Rezoning Transportation Analysis

Petition Number: 2021-090

Date	Description
8-20-2021	First Review (DBS)
9-23-2021	Second Review (BB)
10-27-2021	Third Review (AO)

The site is located on a major thoroughfare, Mallard Creek Road. A Traffic Impact Study (TIS) is not needed for this site. The petitioner will construct an 8 foot planting strip adjacent to Mallard Creek Road with a 12 foot multi-use path to accommodate pedestrians and bicyclists. The petitioner has committed to dedicating right-of-way to 2 feet behind the proposed multi-use path. All CDOT comments have been addressed.

SHEET NUMBER
RZ101

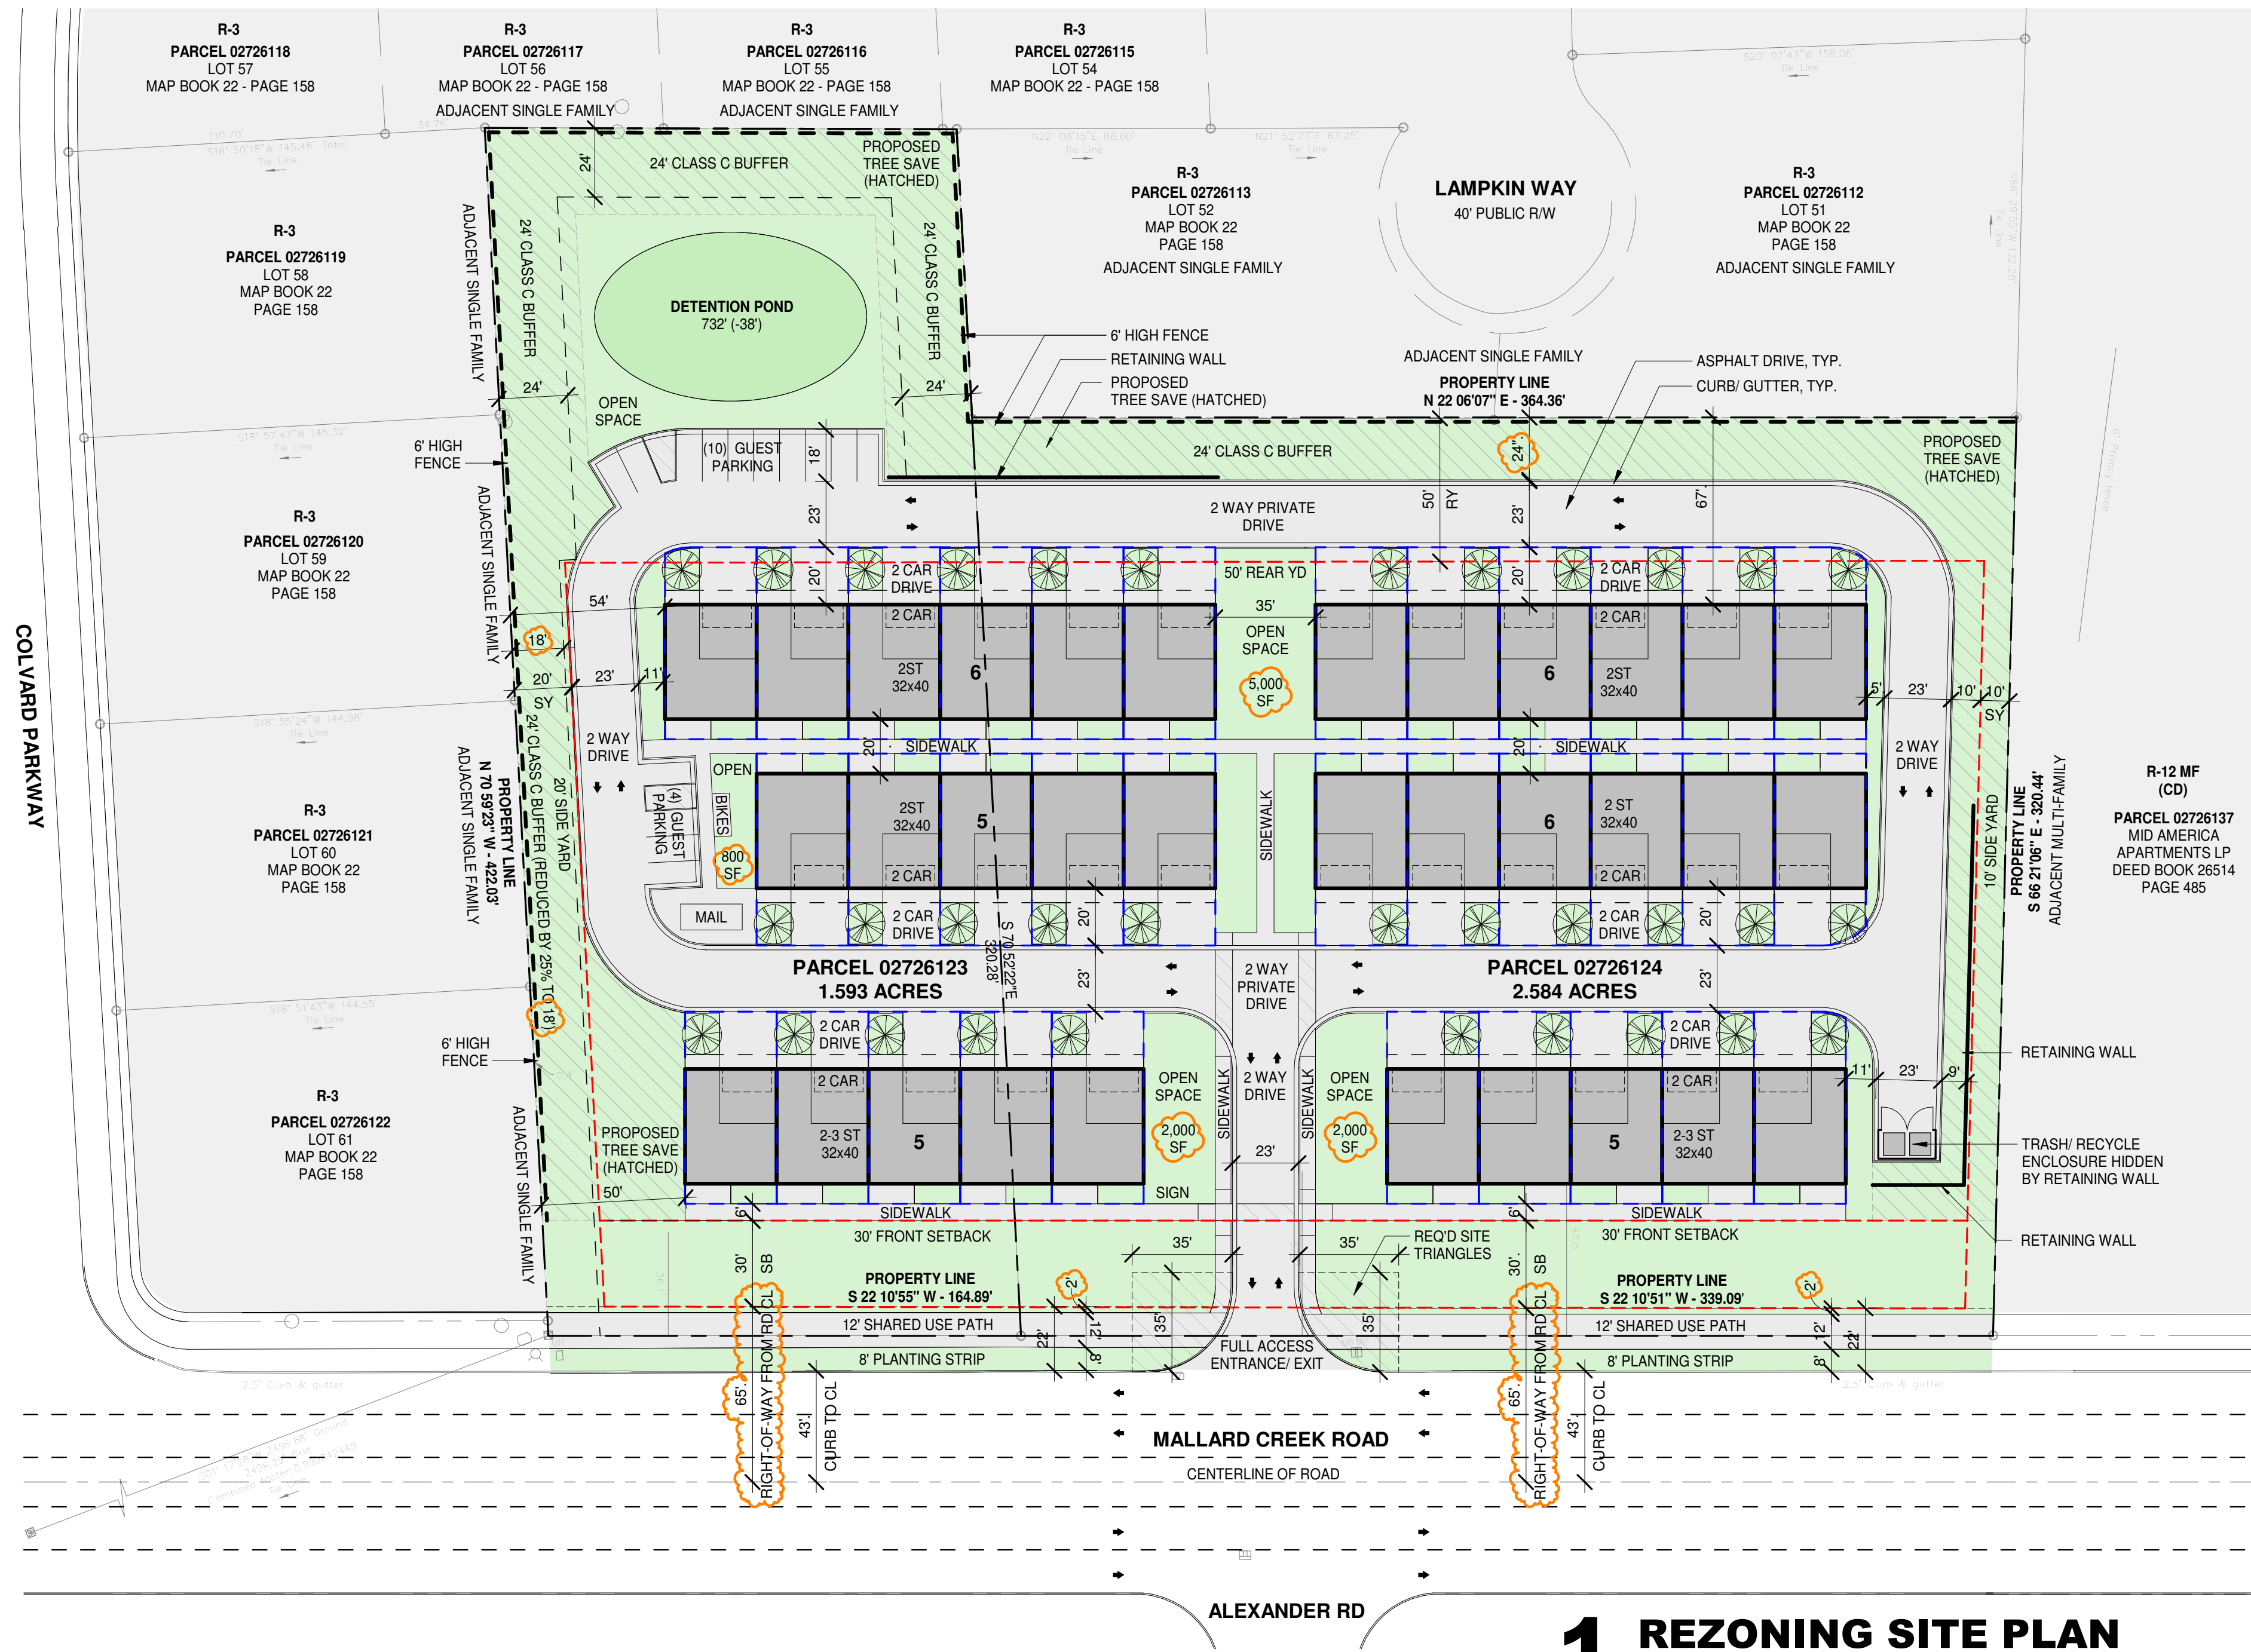
2. ~~**Outstanding Comment (site plan dated: 9-1-2021):** The site plan reflects dedicating 90' of right-of-way from the road centerline. Based on the street classification and street/streetscape elements, this right-of-way width is not needed and can be reduced to the distance from the road centerline to 2' behind the back of the shared use path. Revise site plan to label and dimension the right of way from the road centerline based on the above.~~

~~Revise site plan to locate the planting strip adjacent to the back of curb and the shared use path between the planting strip and the site.~~

3. ~~**Outstanding Comment (site plan dated: 9-1-2021):** A site plan note(s) specifying dedication and fee simple conveyance of all rights-of-way to the City before the site's first building certificate of occupancy is issued is needed. As noted above, CDOT requests rights-of-way be set at 2 feet behind the back of shared use path where feasible.~~
